**Consultation Response from KC,
 Highways Development Management**
2021/91283 Waverley House, Waverley Street, Huddersfield, HD1 5NA
Installation of roof lights and formation of car parking (within a Conservation Area)
**Date Responded:
 03/06/2021**
**Responding Officer: Zack
 Turner**
Responding Ref: 5-5SE-36

2021/91283

BLOCK/SITE PLAN
AREA 90m x 90m
SCALE 1:500 on A4
CENTRE COORDINATES: 413926, 417002

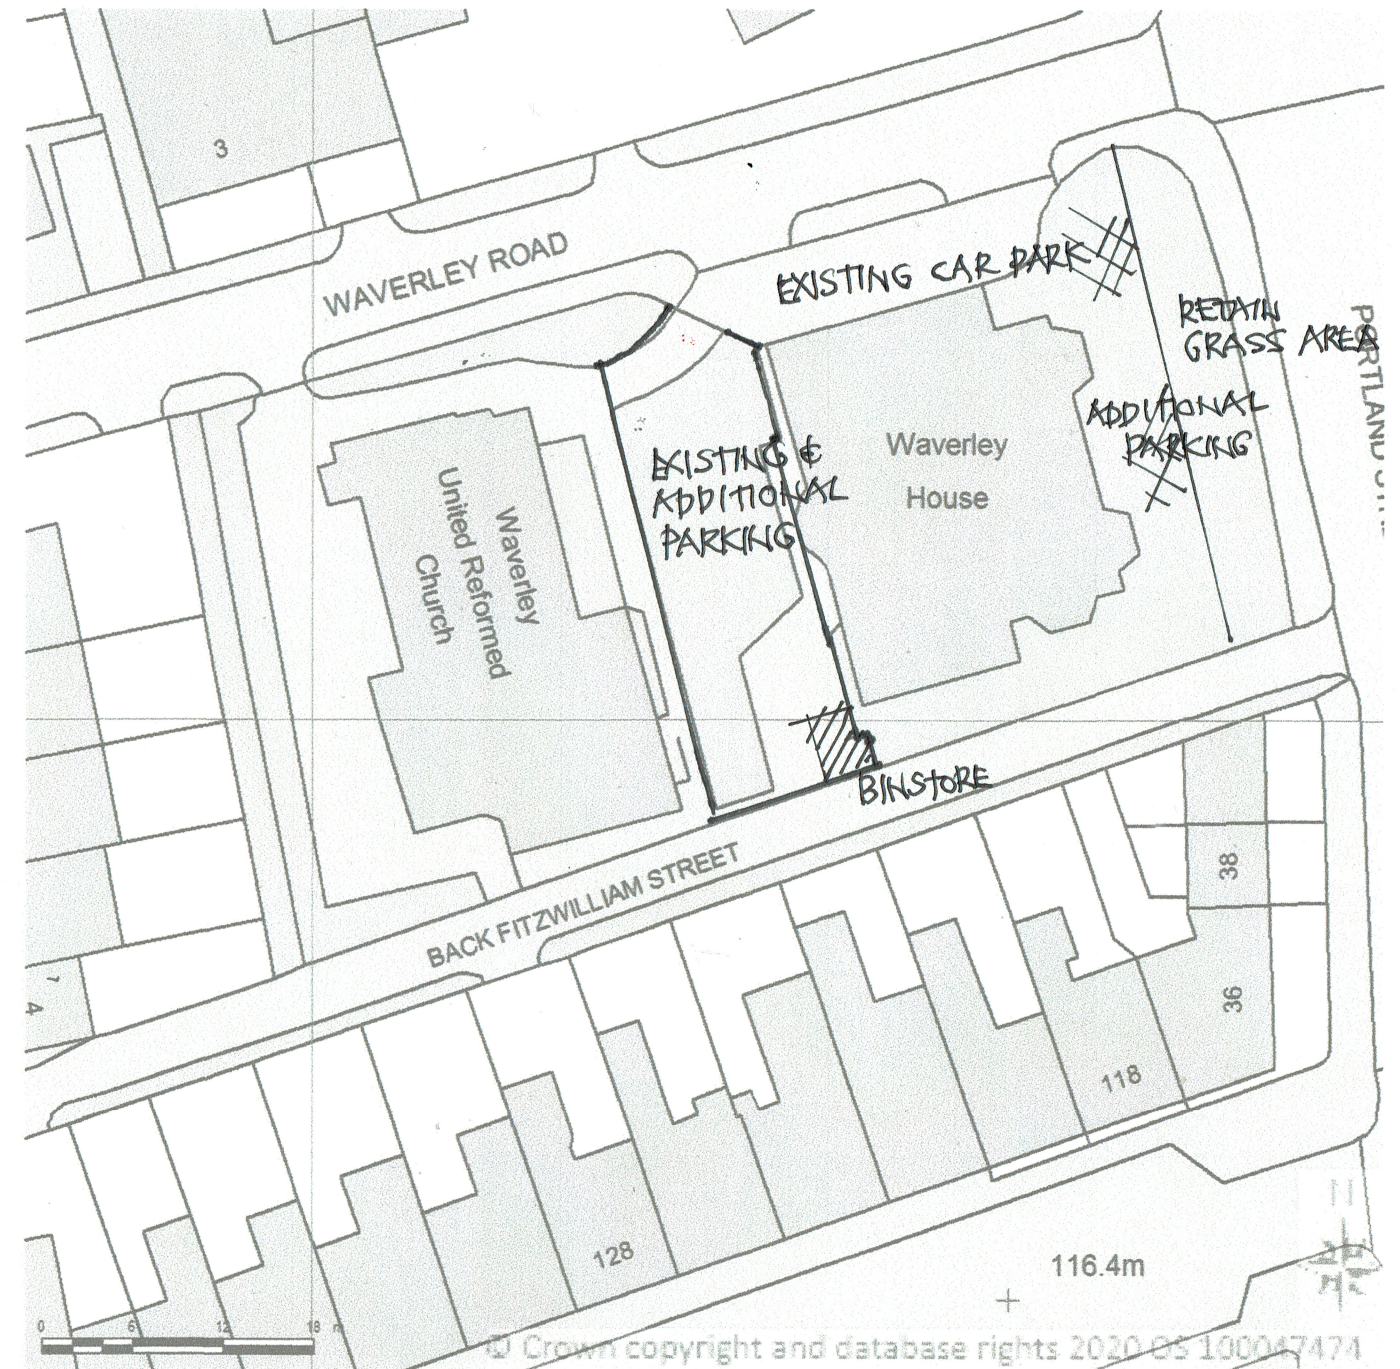
The site has 10 existing parking spaces, and it is proposed to create an additional 20 spaces. The areas for the parking have been demonstrated but HDM requests that each parking space is marked out on a plan which will also indicate the turning area available for each space.

The 4 flats on the second floor will each have 2 bedrooms and HDM requests that out of the new 20 parking spaces, the ones that will be providing parking for the flats are clearly demonstrated on a plan.

Bin storage has been presented in a suitable location, but no details have been provided regarding waste collection. HDM requests that a waste collection point is clearly shown on a plan.
